re: Grading & Site Servicing Plan Review
Proposed Development
2300 Bank Street - Ottawa, Ontario
to: Trinity – Mr. Robert Wells – rwells@trinity-group.com
date: April 14, 2026
file: PG7467-MEMO.01

Further to your request, Paterson Group (Paterson) prepared this memo to document our Grading Plan Review for the proposed development to be located at the subject site. This memo should be read in conjunction with the current Geotechnical Investigation Report (No. PG7467-1 Revision 1 dated December 18, 2025).

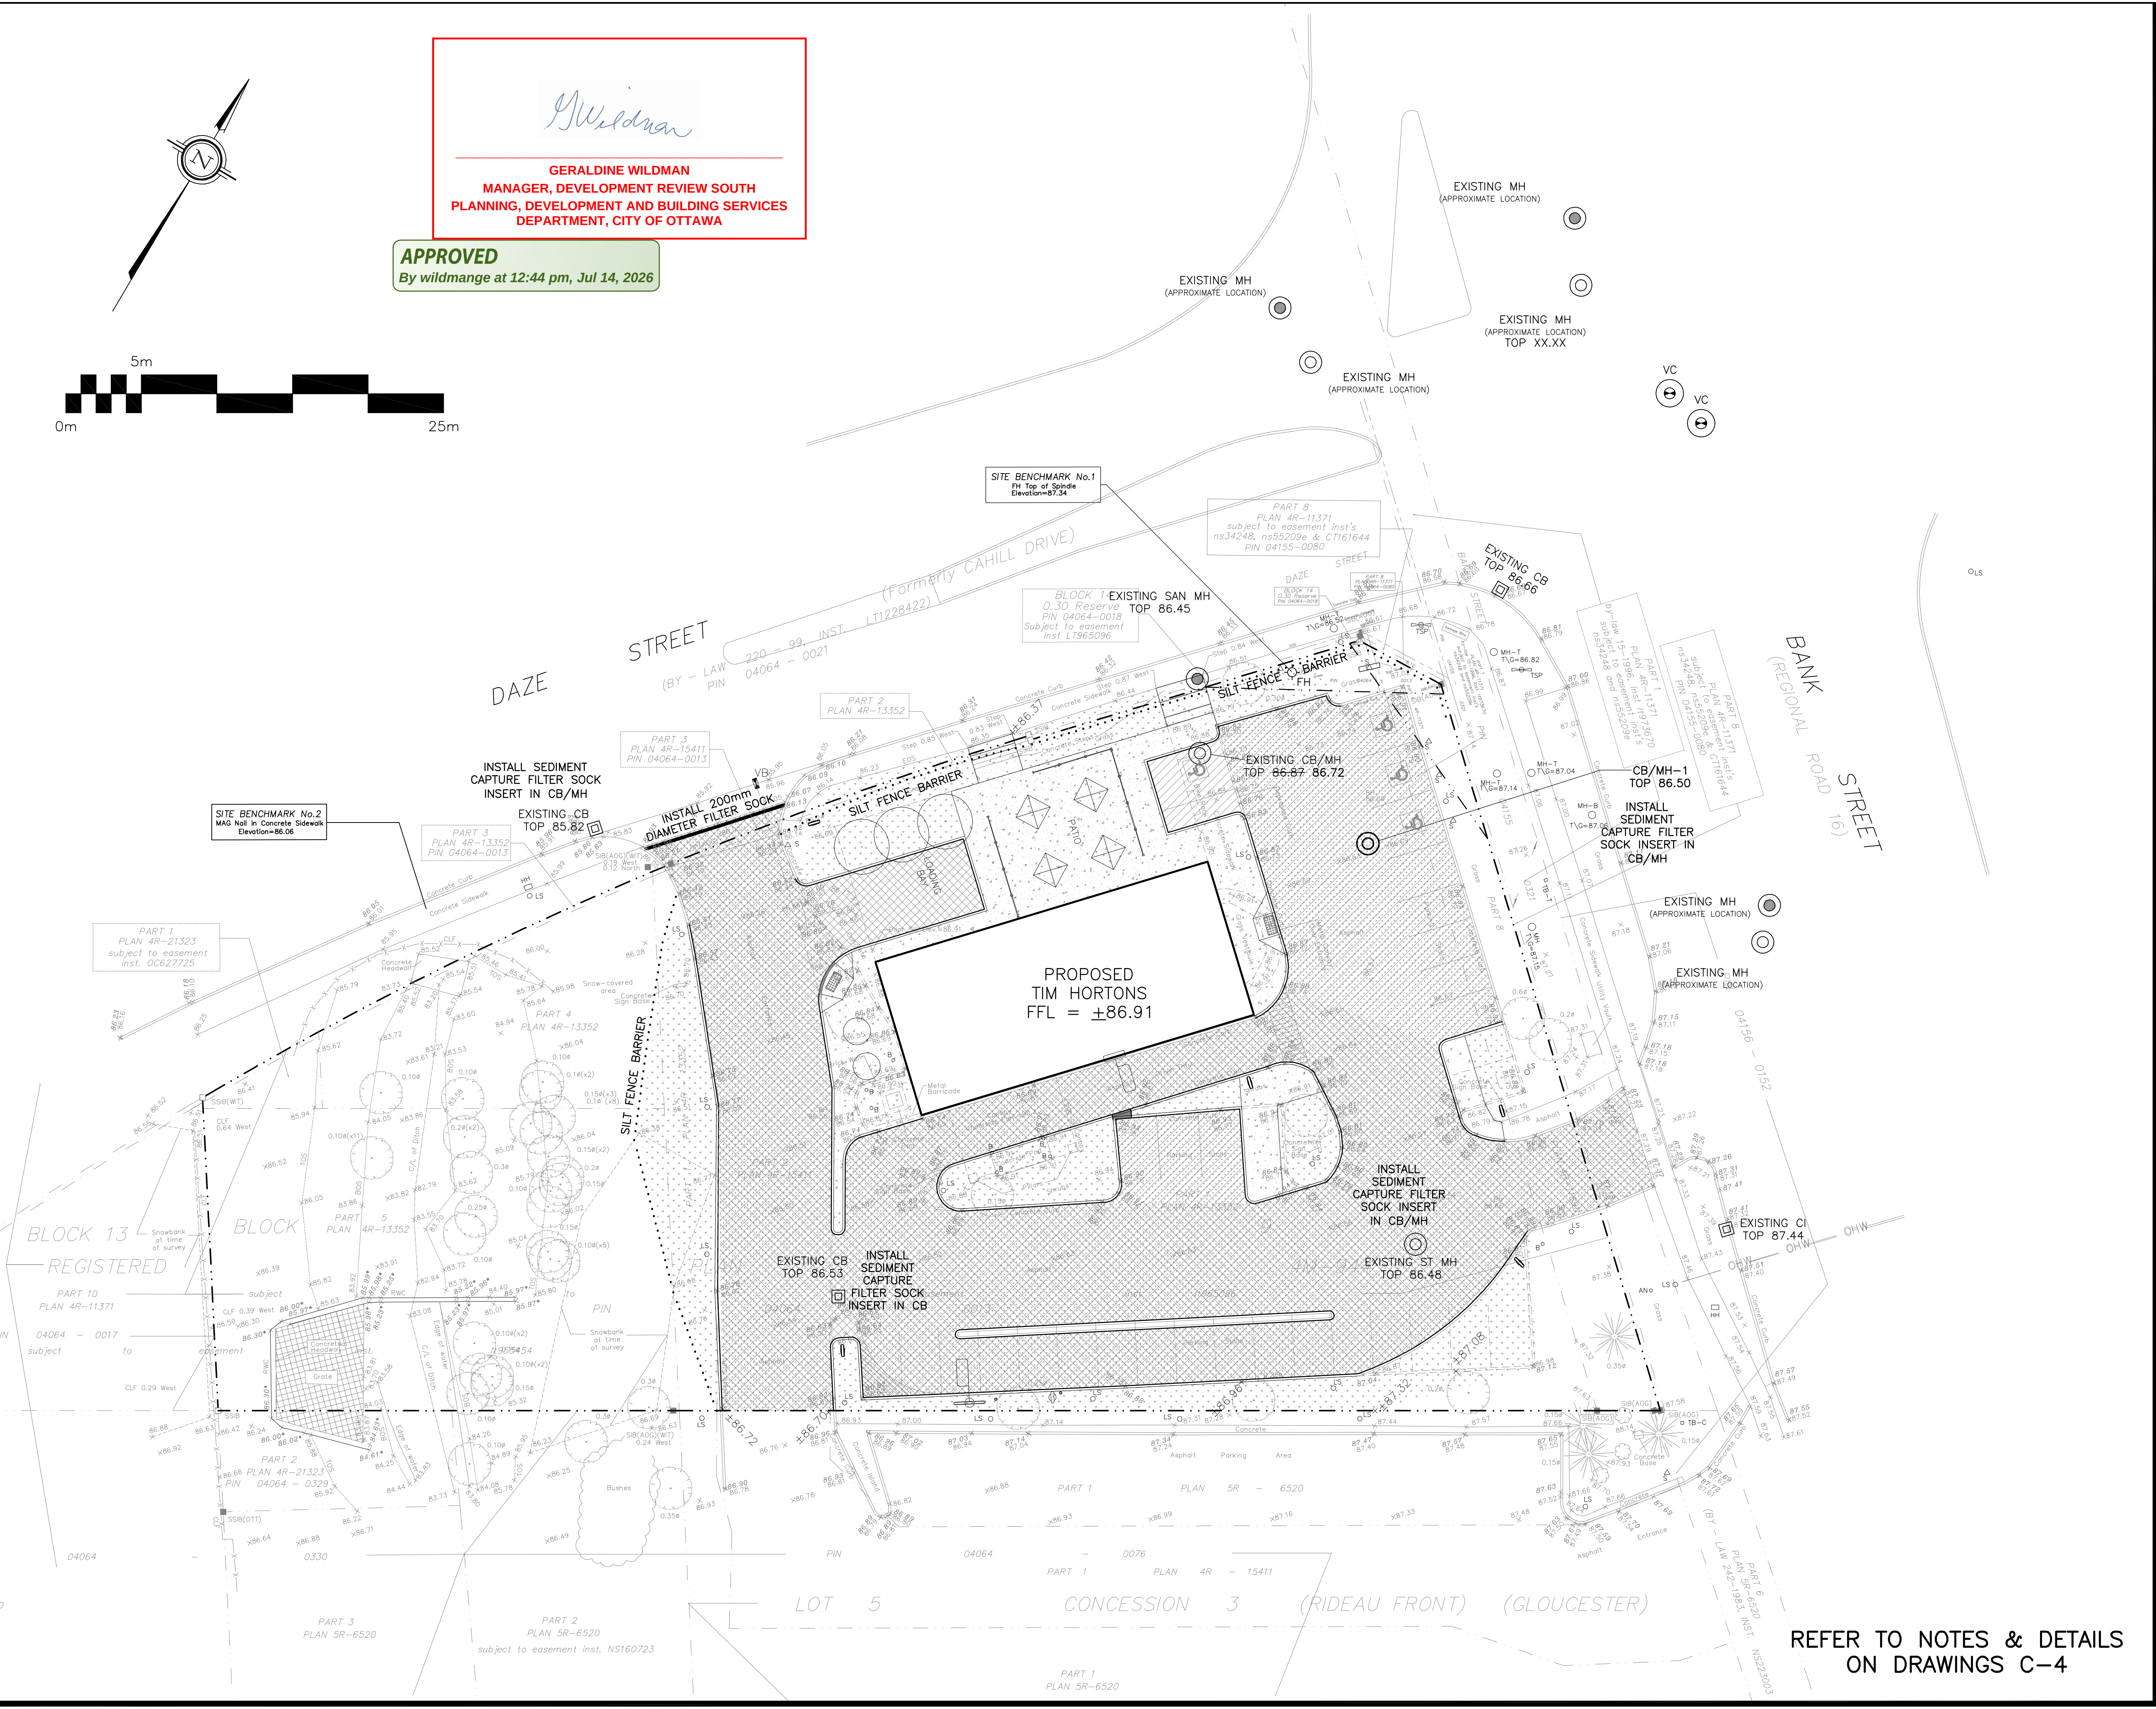
Many of the existing and proposed servicing pipes do not have sufficient soil cover of 2.1 m over the obverts of the pipes. Therefore, insulation of these pipes is recommended, which is illustrated on the attached drawing C-1.

Drawing No.
C-3
of 6

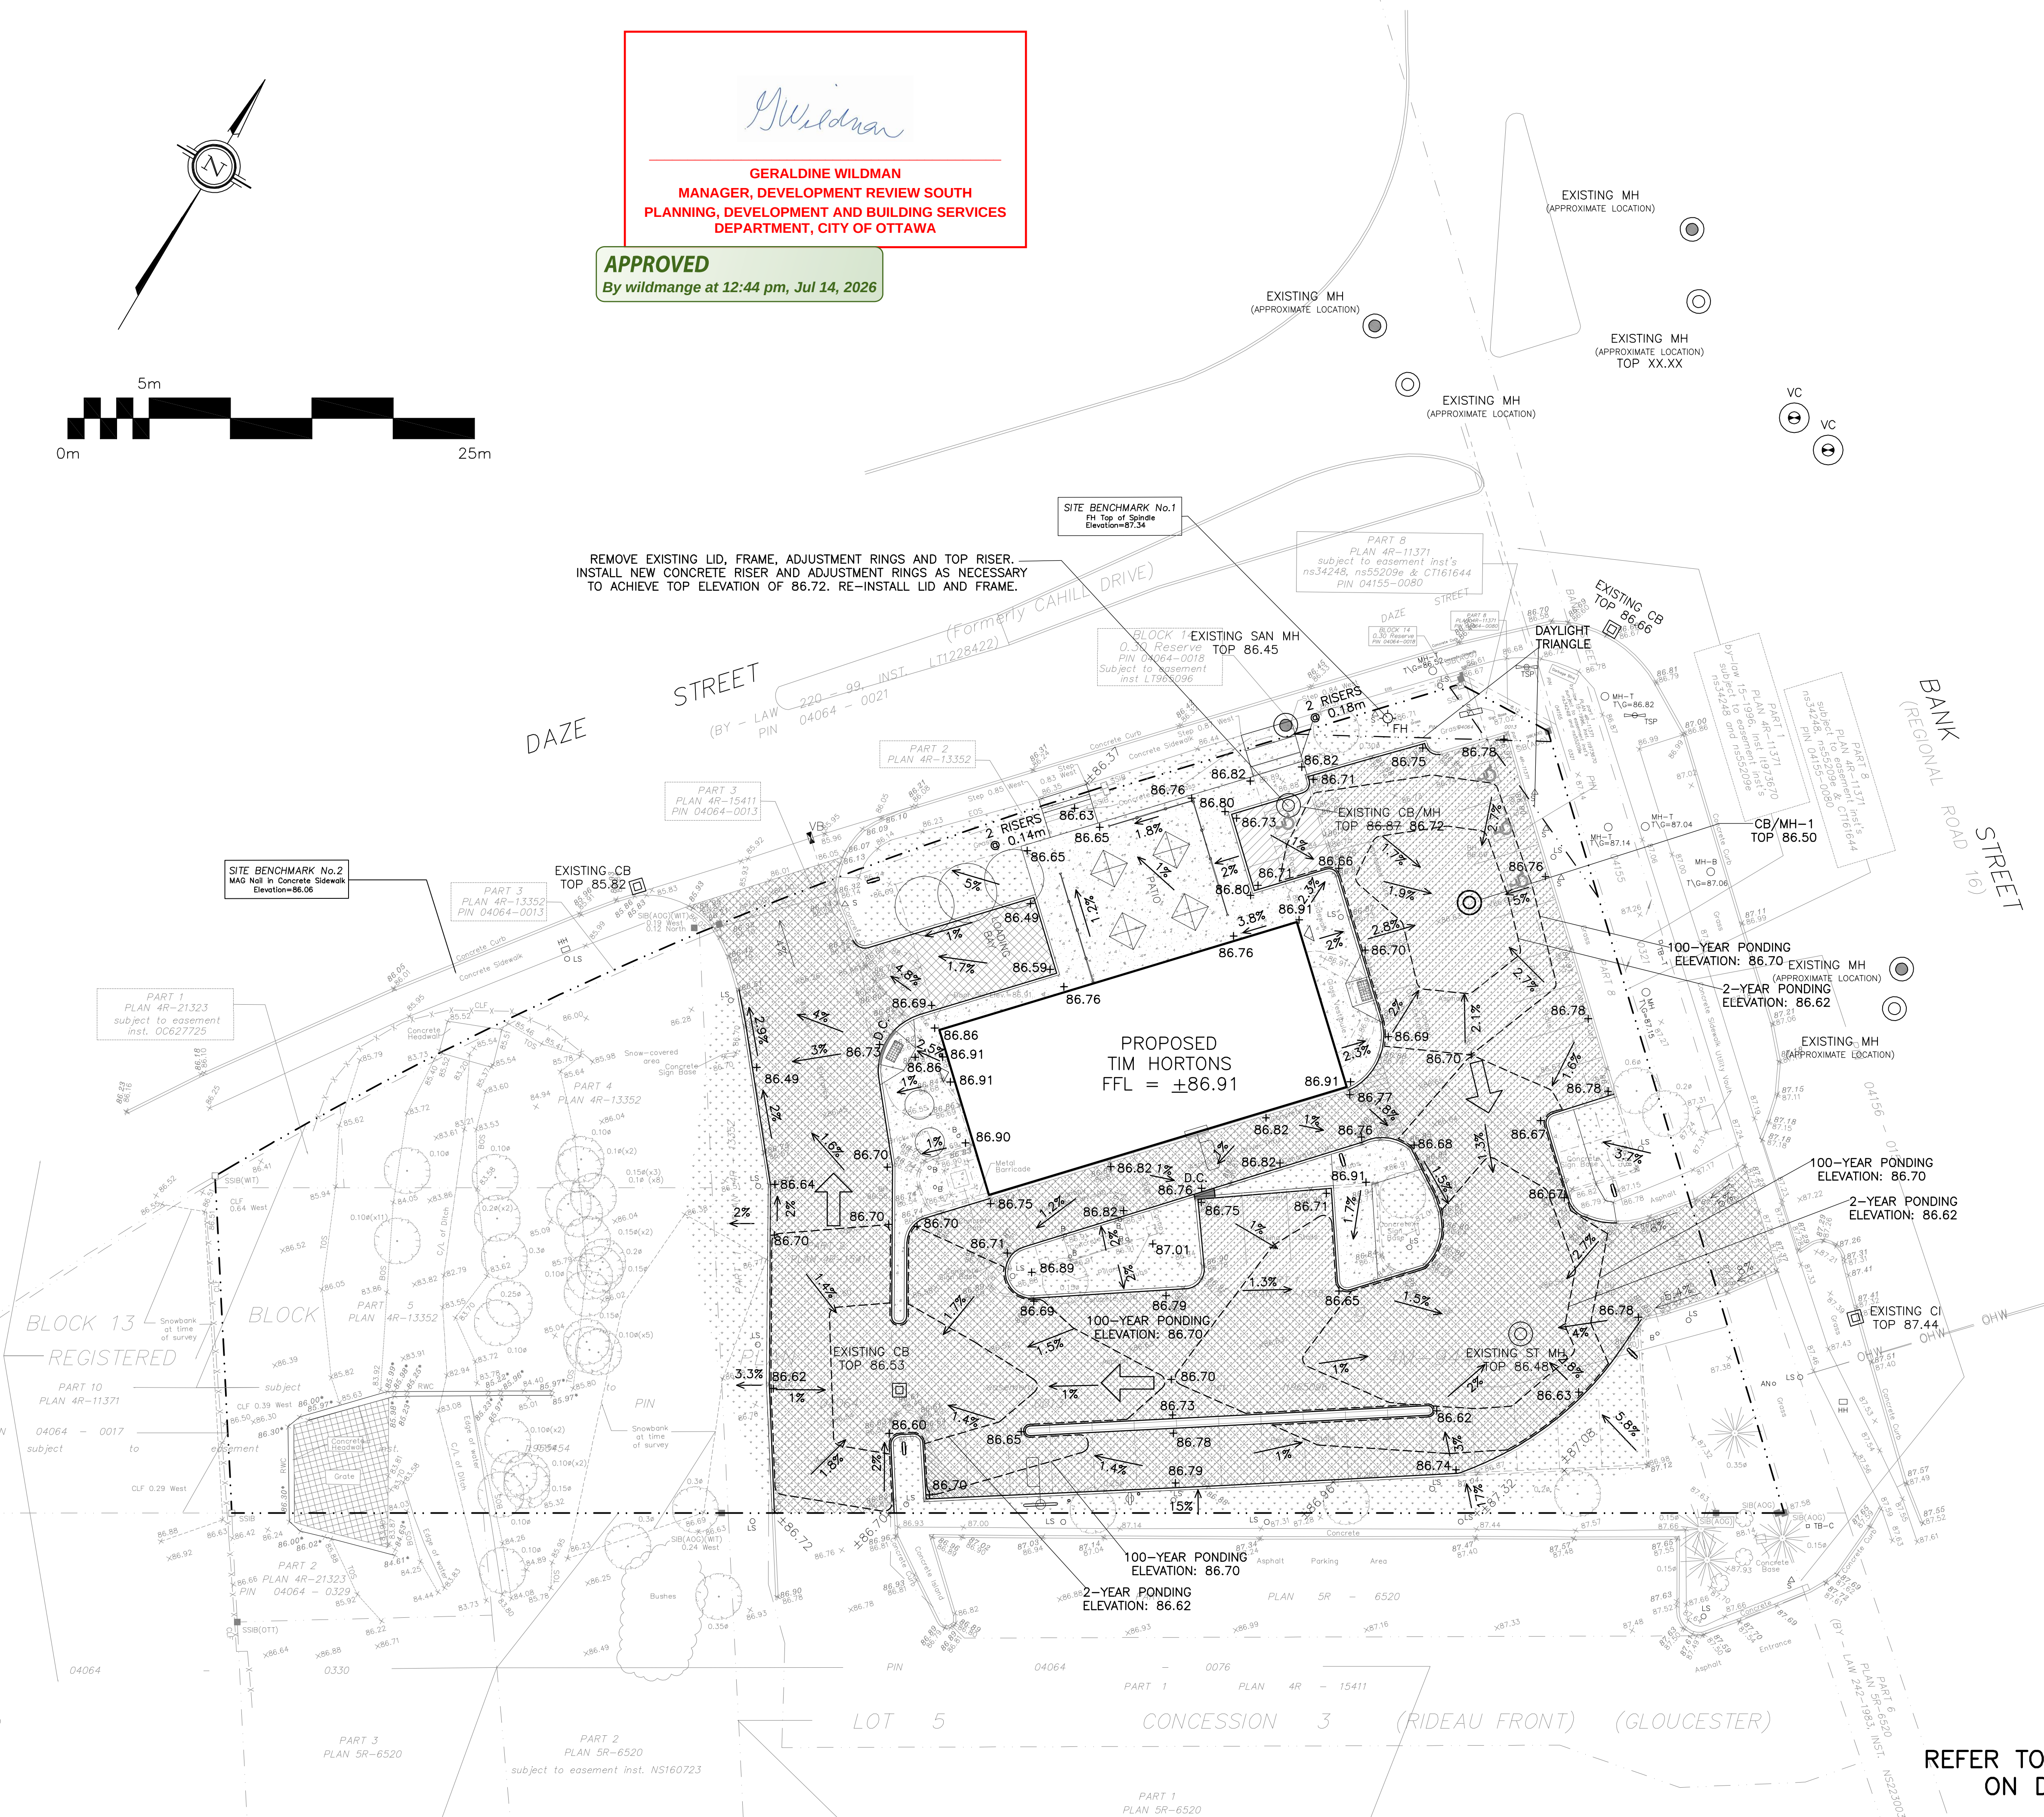
Based on our review of the Grading Plan, the proposed grading at the subject site does not exceed the permissible grade raise restriction of **1.0 m**. Therefore, the proposed grading is acceptable, from a geotechnical perspective.
